# BUILDING PERMIT

Job ID: 2012-03-3567-ALTR

has permission to modify existing deck to enclosed three (3) season porch (Single Family Residence).  
provided that the person or persons, firm or corporation accepting this permit shall comply with all of the provisions of the Statues of Maine and of the Ordinances of the City of Portland regulating the construction, maintenance and use of the buildings and structures, and of the application on file in the department.

## Conditions of Approval:

Drawing # 2

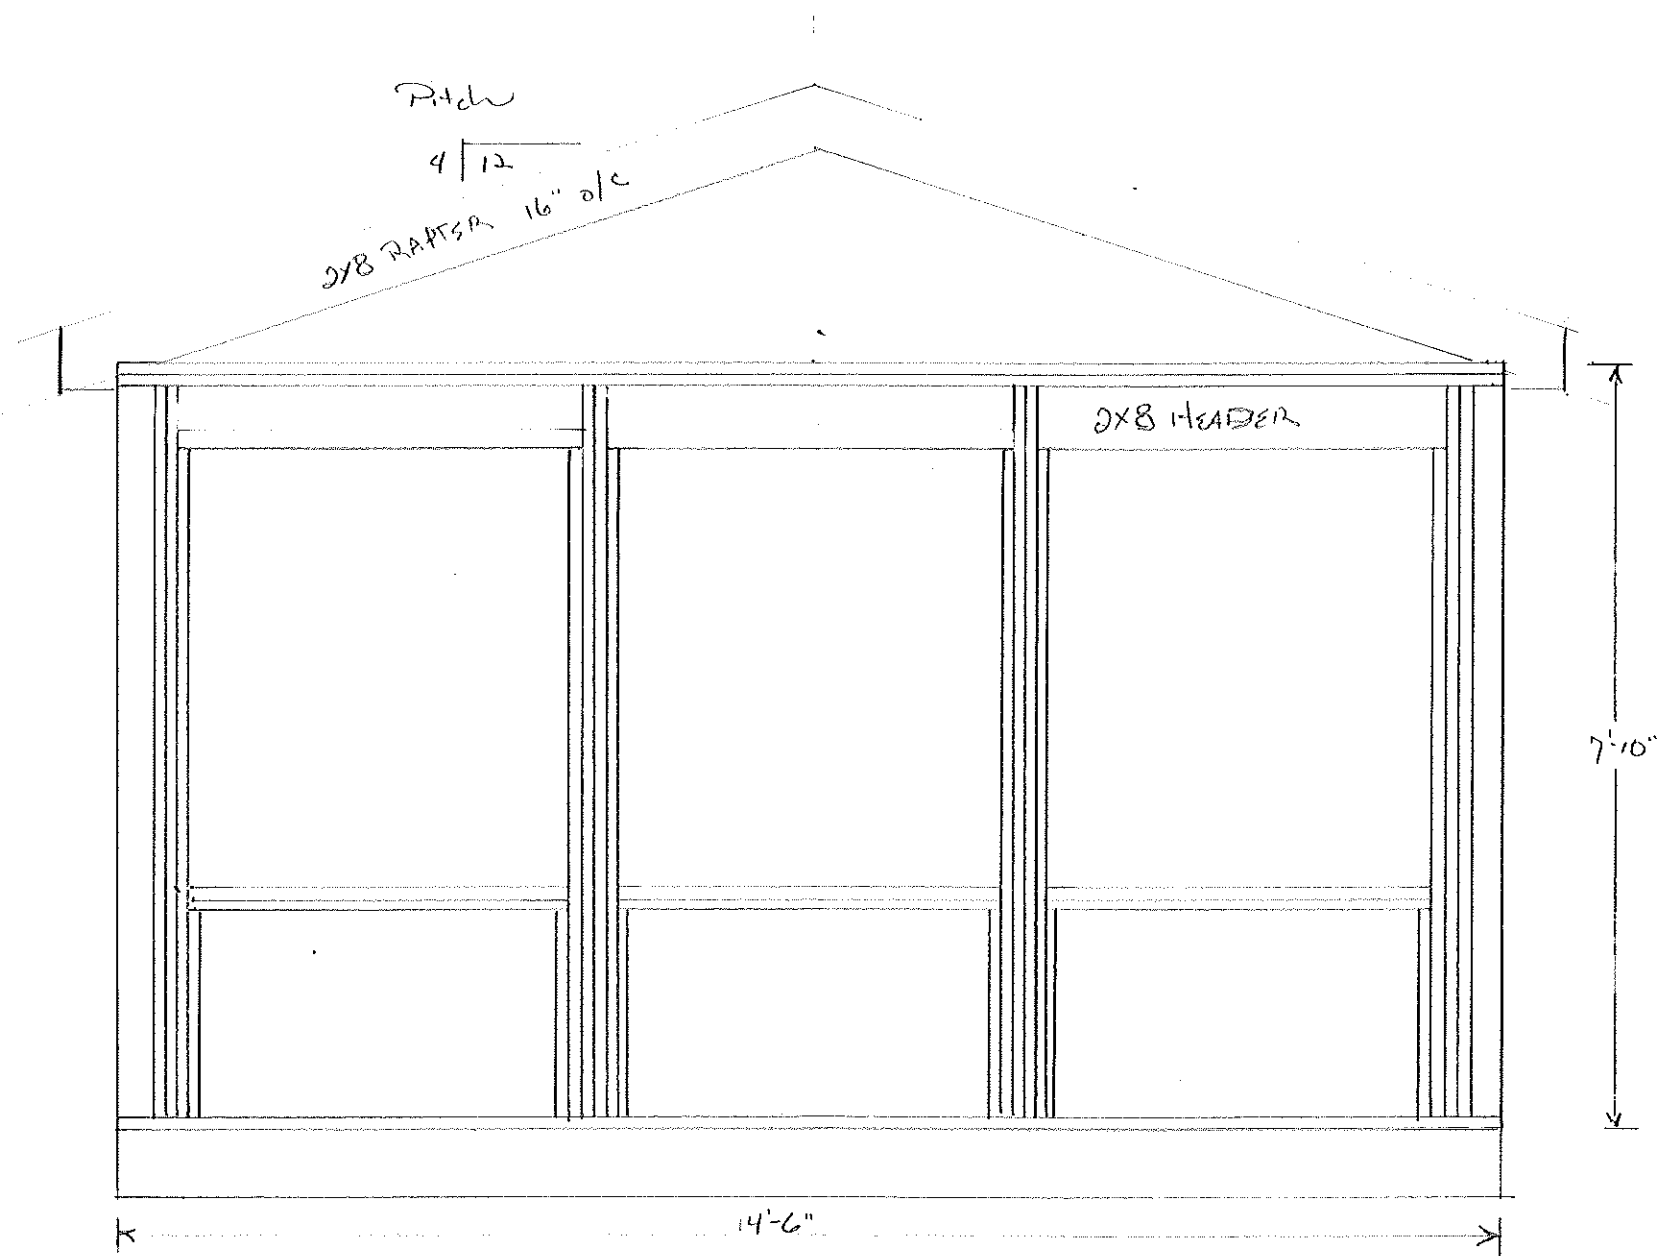
2. A graspable handrail (34-38 inches in height) shall be provided on at least one side of each continuous run of treads or flight with four or more risers. Fall protection (36 inches) from exterior decks may be required if floor joist are at or above thirty (30) inches from grade.

4. Roof Rafter framing and Connection shall comply with Section R802.3 & R802.3.1 of MUBEC. **Collar ties shall be a minimum of 1-inch by 4-inch (nominal), spaced not more than 4 feet on center.**

5. R502.6 Bearing. The ends of each joist, beam or girder shall have not less than 1.5 inches of bearing on wood or metal and not less than 3 inches on masonry or concrete except where supported on a 1-inch-by-4-inch ribbon strip and nailed to the adjacent stud or by the use of approved joist hangers.

6. Note: **See attached documentation for Safety Glazing in Hazard Areas;** Existing Header/ Door opening will be utilized for porch entry.
